**Sunflower Landscapes
Variance of Use
Letter of Intent**

March 31, 2026

PDC File No. VA26XX **VA265** RESPONSE: added

The purpose of this application is to request approval of a variance of use to allow for a contractor equipment yard in the RR-5 zoning district. The pages that follow address each one of the Variance of Use criteria included within Section 5.3.4 of the El Paso County Land Development Code:

PRELIMINARY LANDSCAPE PLAN

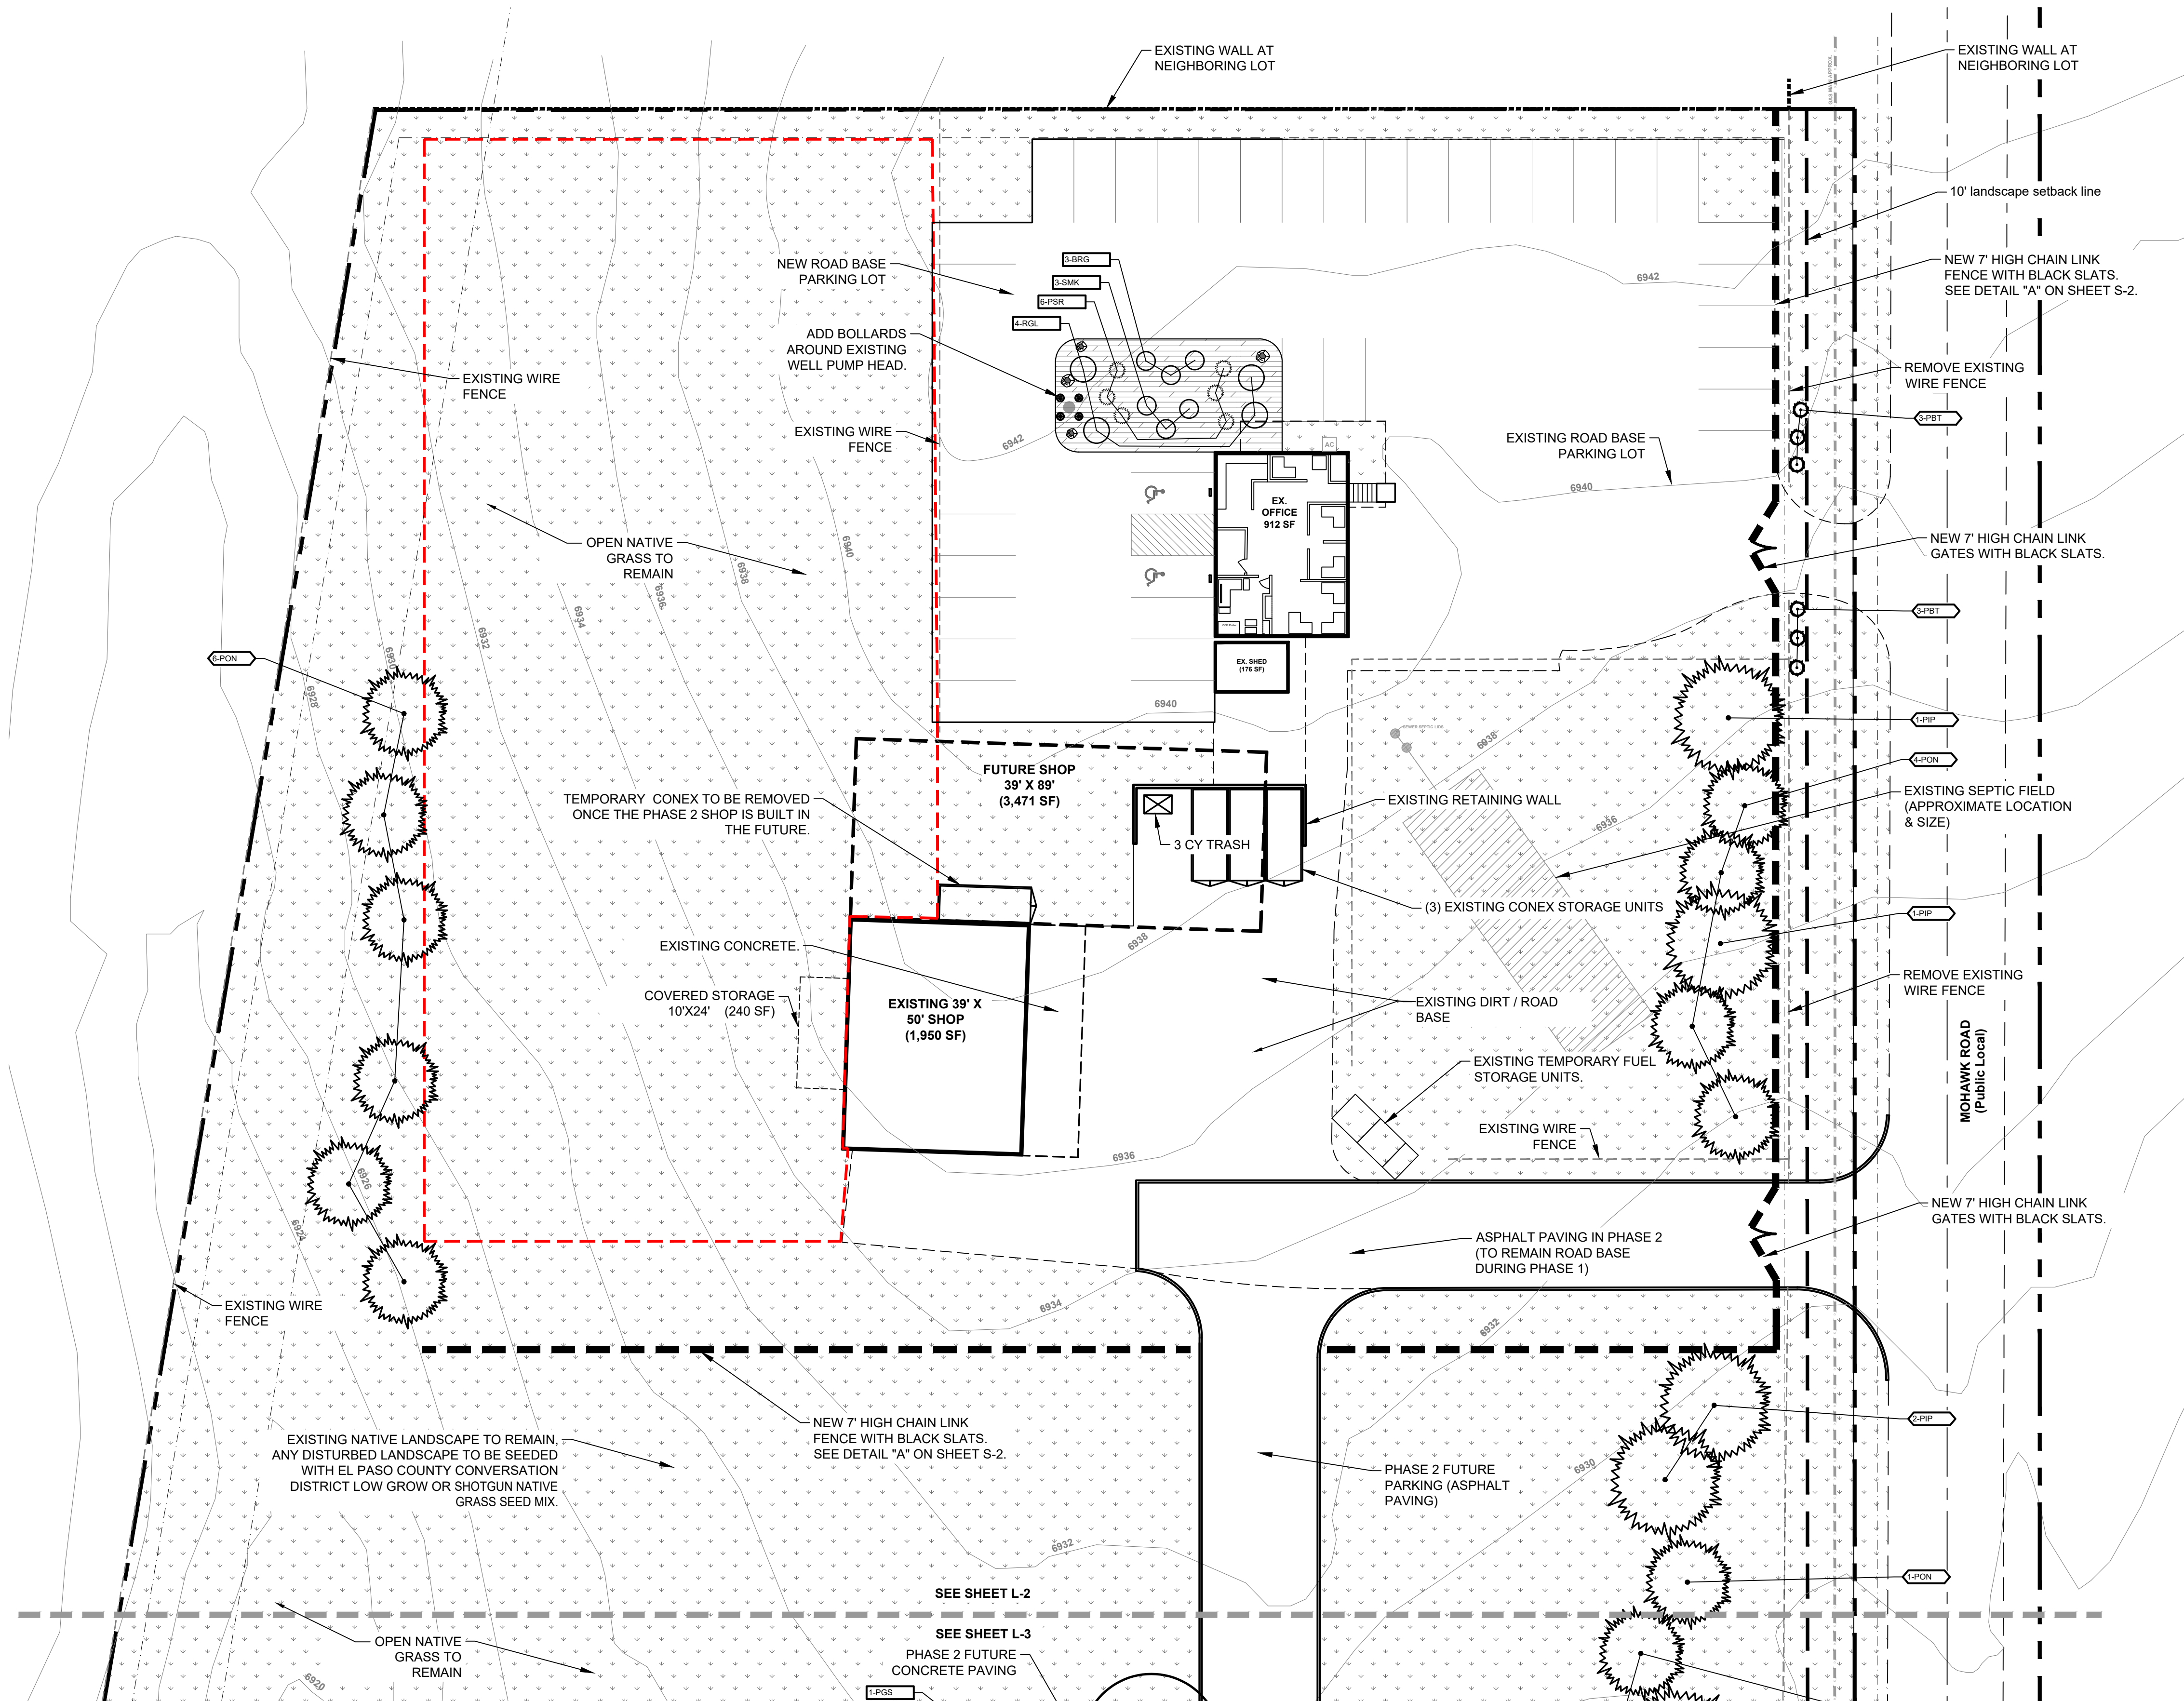
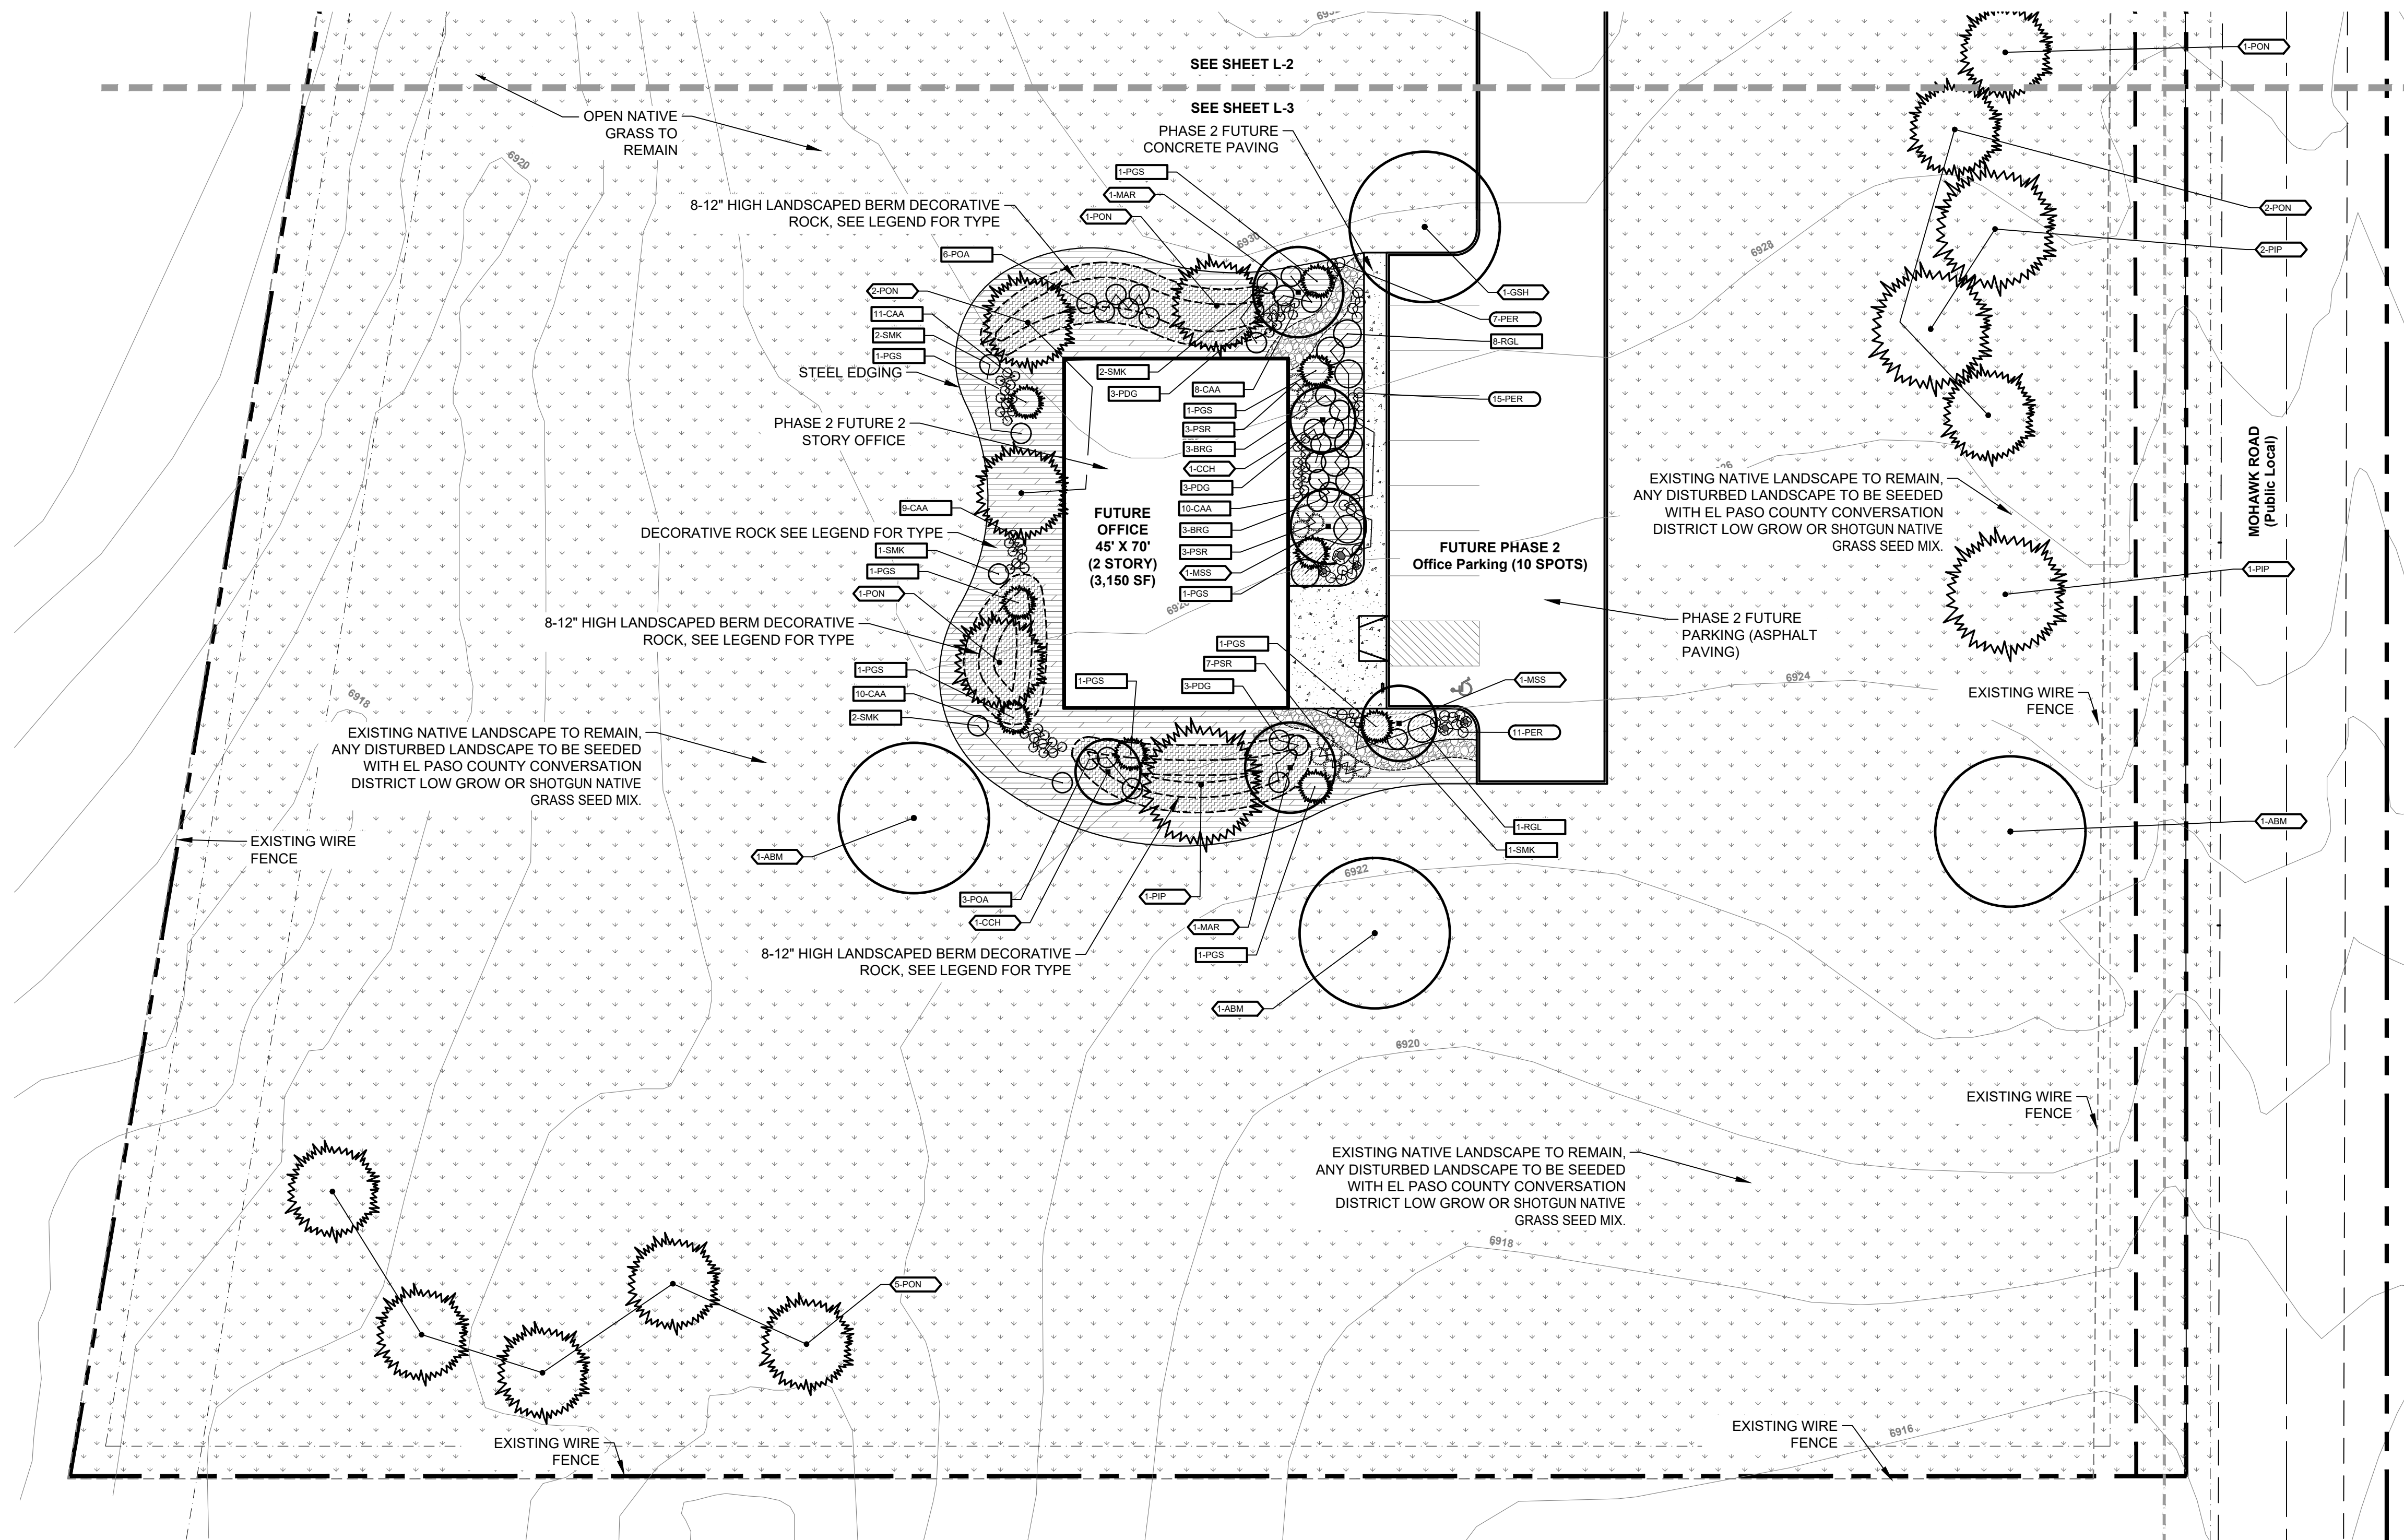
Please discuss or revise how adequate parking will be provided to support the proposed number of employees, as the submitted site plan currently identifies only 47 parking spaces (some of which are identified for customers).

The site plan shows that guest parking is included. Please revise site plan or include discussion of customer traffic in the LOI.

RESPONSE: see page 8 where it is discussed that employees have historically carpooled to work. the TIS also provides greater detail.

RESPONSE: this was an error on the site plan.
